P. Watson Responses

ExQ2: 20 June 2023

Ex Q1	Question to	Question
Q4.3.21	Carter Jonas LLP for Mr P Watson	<p><b>Mr P Watson interest in land at the Tadcaster CSECs/ location of western CSEC</b></p> <p>The Applicant responded to the points made in your Relevant Representation [RR-006] at Deadline 1 [REP1-015] and to your points made at the Issue specific Hearing 1 (ISH) [EV-003b] and [REP1-017], Table 2.3. It has set out its view on progress to reaching agreement in the Updated CA and TP Objections' Schedule [REP4-020], objection 3. On the ASI [EV-001b] and at CAH1, the Applicant also indicated a possible reorientation of the western CSEC and submitted an indicative plan in this regard [REP4-024], Table 2.3, item 5e. and [REP4-027], Appendix B.</p> <p>a) Would the concerns that you raised in your RR and at the OFH regarding the location of the western CSEC and its impact on farming activities be resolved by the proposed CSEC reorientation? Would you be you satisfied with this arrangement?</p> <p>b) If not, set out the matters which are still subject to resolution</p>

Figure 8: Earthworks required for Maximum Legal Length vehicle

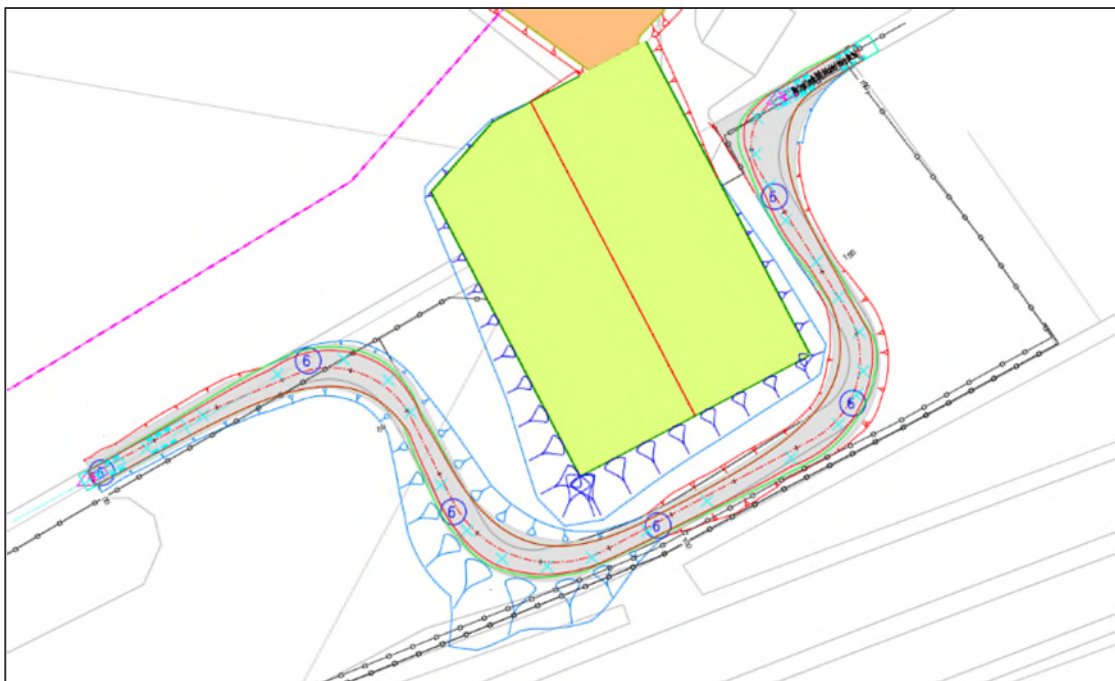
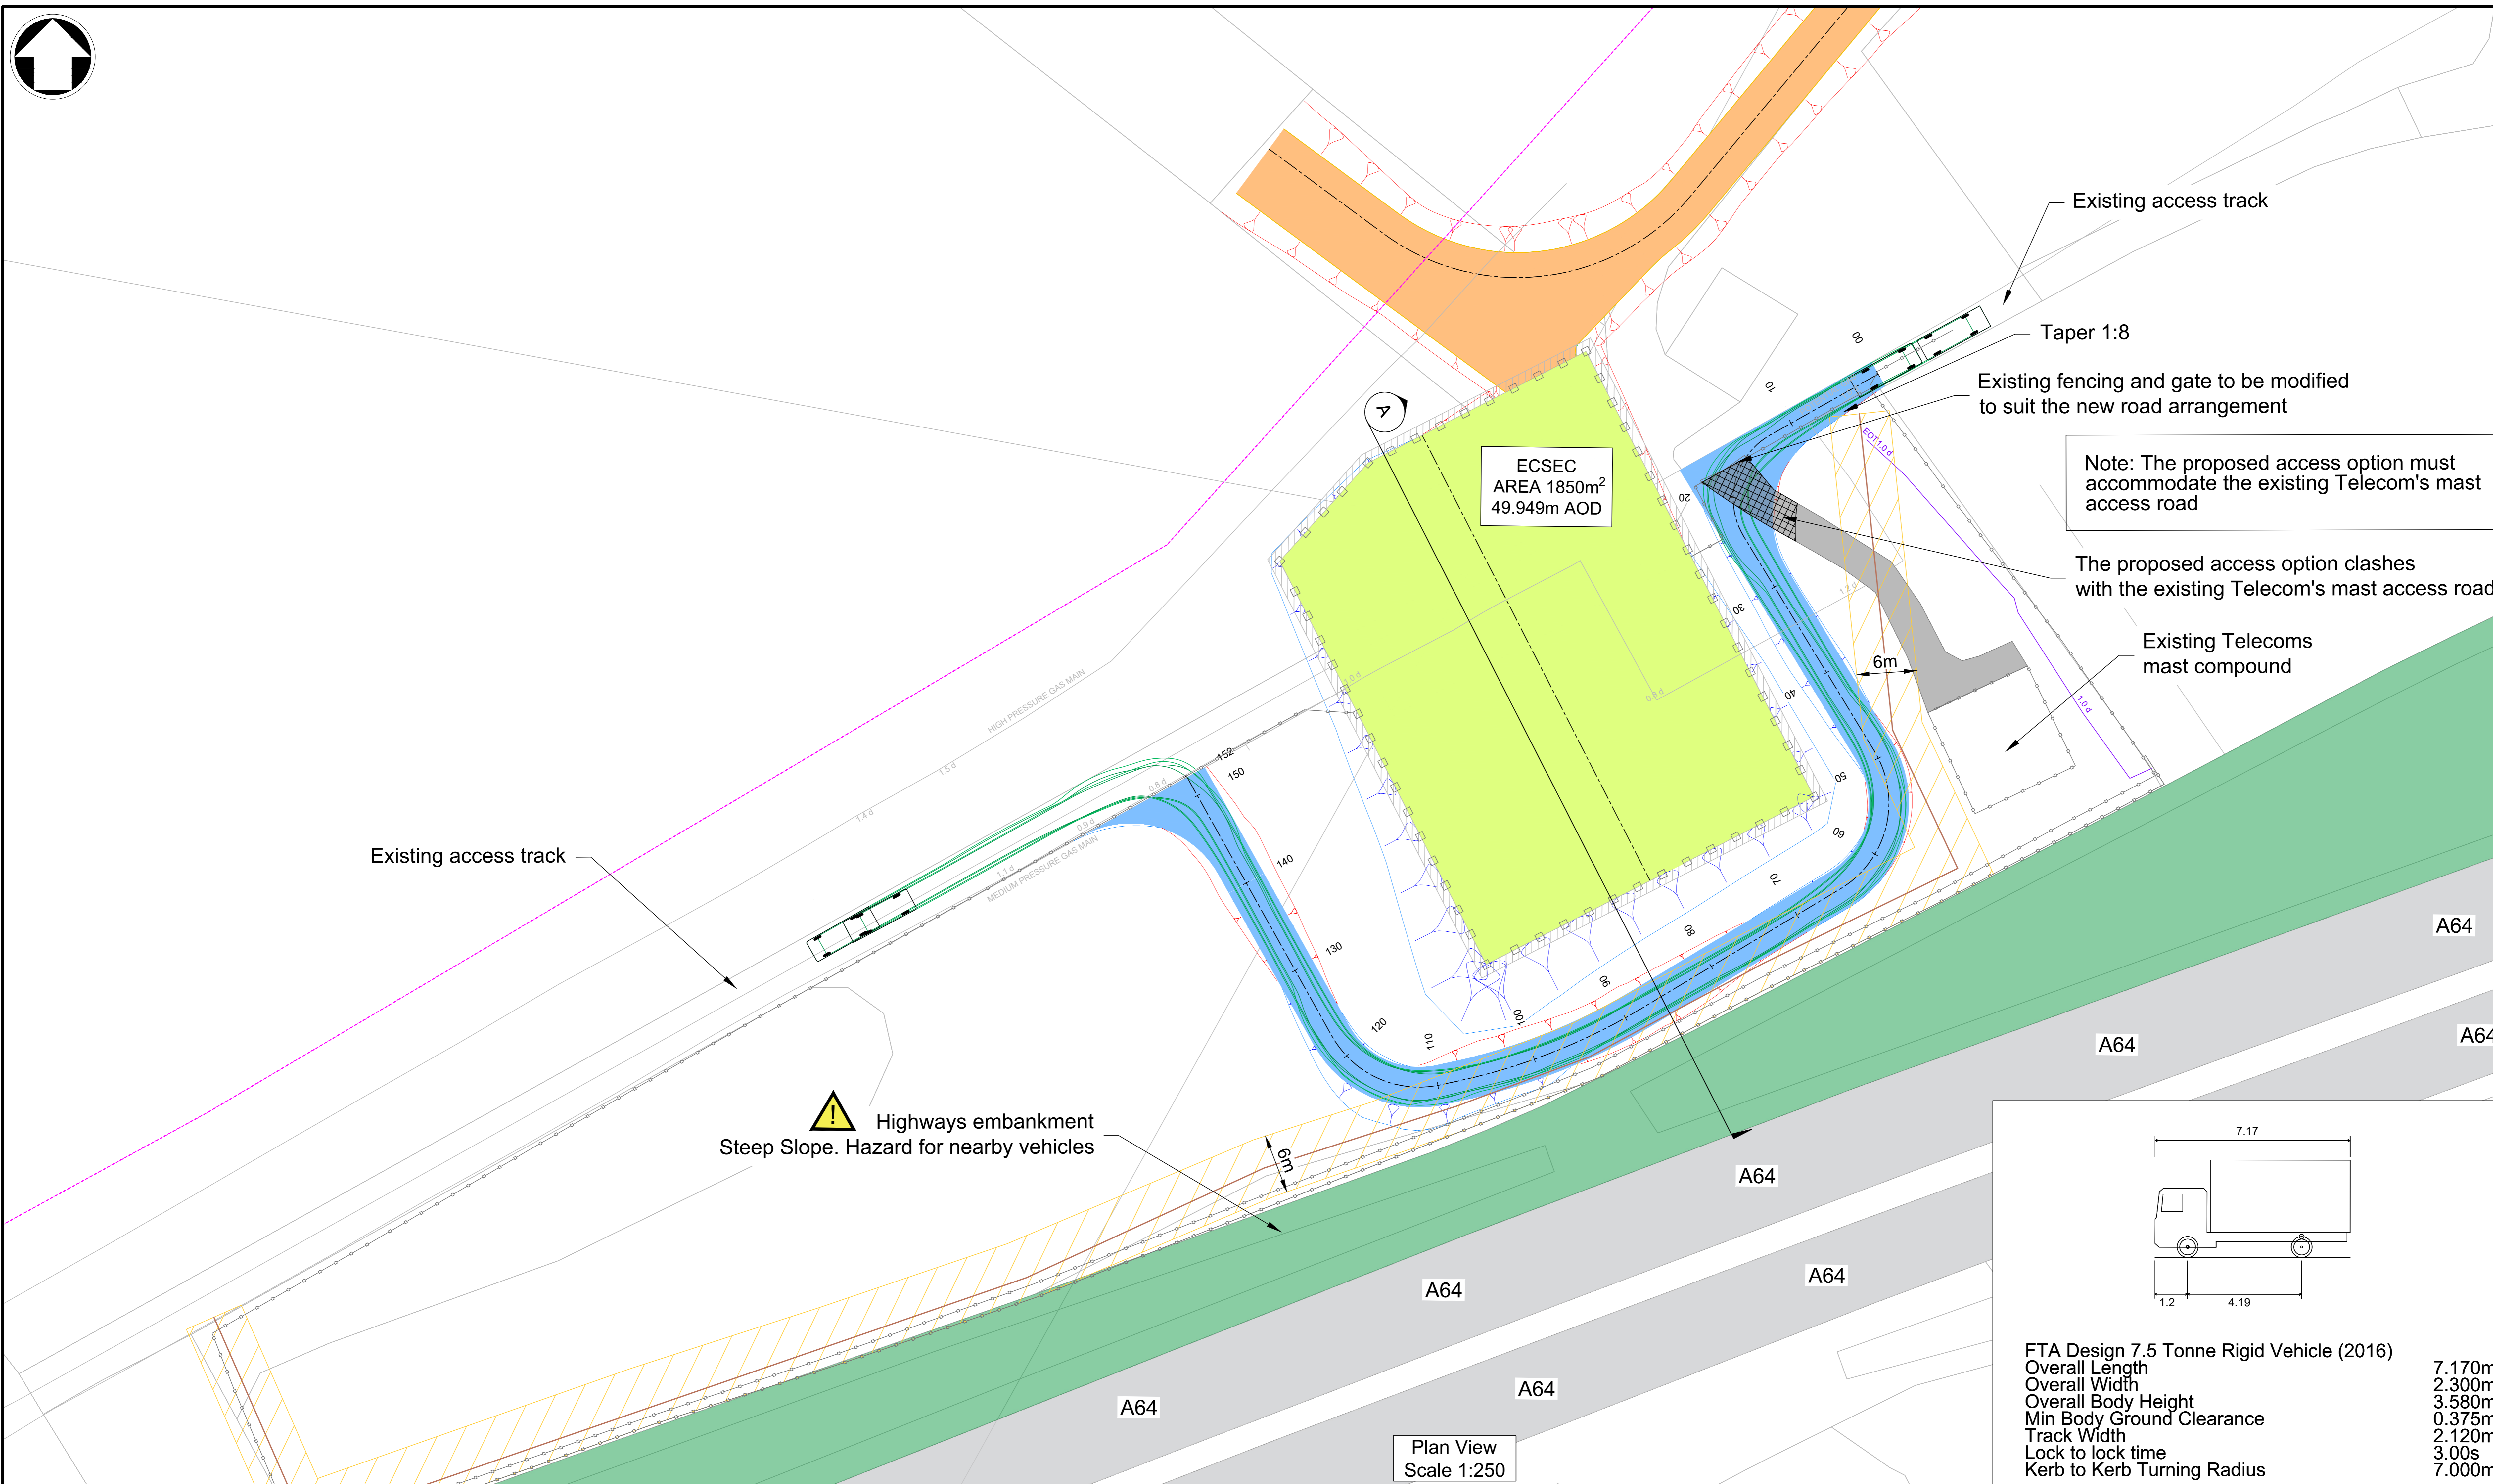
Response	<p>In REP2-039, P149-170 National Grid set out the swept path analysis of various vehicles that could use the area of land between the CSEC and the A64 using just an earthworks bank. There is no mention of a retaining wall being present in that report. The earthworks bank solution clearly leaves a flat 6 metre strip for vehicles to travel on. Only the very longest road going vehicle could not get through (and that was only slightly on the edge of the limits) and all agricultural vehicles tested could. I am unlikely to want to take an articulated vehicle along the 6 metre wide strip. I suggested at our meeting on 15<sup>th</sup> May 2023 that for the new diversion route around the CSEC they could include a right of way on the same terms but exclude articulated lorries. I am yet to hear back from them on that. Even if a slight camber remained on the strip of land, agricultural vehicles would easily be able to travel along it, it is after all what they do every day. Of course if they put in a retaining wall I could take any vehicle along the new right of way which is what I would want ideally and is certainly possible. If the cost of the retaining wall really was the issue they would have said so straight away. Sadly I am left with the impression that National Grid have been determined to extinguish the right of way from the start. I have to point out that in court Mr Ingham made it very clear that he did not want the Right of way running across his land.</p> <p>In the past I have planted two different crops in that field using the A659 access for one part of the field and the right of way for the other part. It is not possible to do this from one access point due to different drilling times and harvest times of the two crops. I will no longer be able to do this in the future if the Right of way is extinguished.</p> <p>In REP1-015 13.5 National Grid state that they would be willing to not proceed with the acquisition of the land to the south of the CSEC East. They would also be willing to provide access to this land for Mr Ingham over the 6 metre strip between the CSEC and the A64 to access this land. Clearly they have no issues with Mr Ingham using this strip for access but have come up with a series of unreasonable excuses for myself. I would also expect that National Grid will want to take vehicles along this strip in order to access the south west side of the CSEC East. Whether it is National Grid or Mr Ingham who end up owning that land, access will be needed along that 6 metre strip to take a tractor with a hedgecutter to maintain the hedge beyond, forestry equipment or even maintenance of the gas pipe. None of the</p>

vehicles involved will be small. Could National Grid confirm whether they have agreed to buy the land to the South west of CSEC East from Mr Ingham?
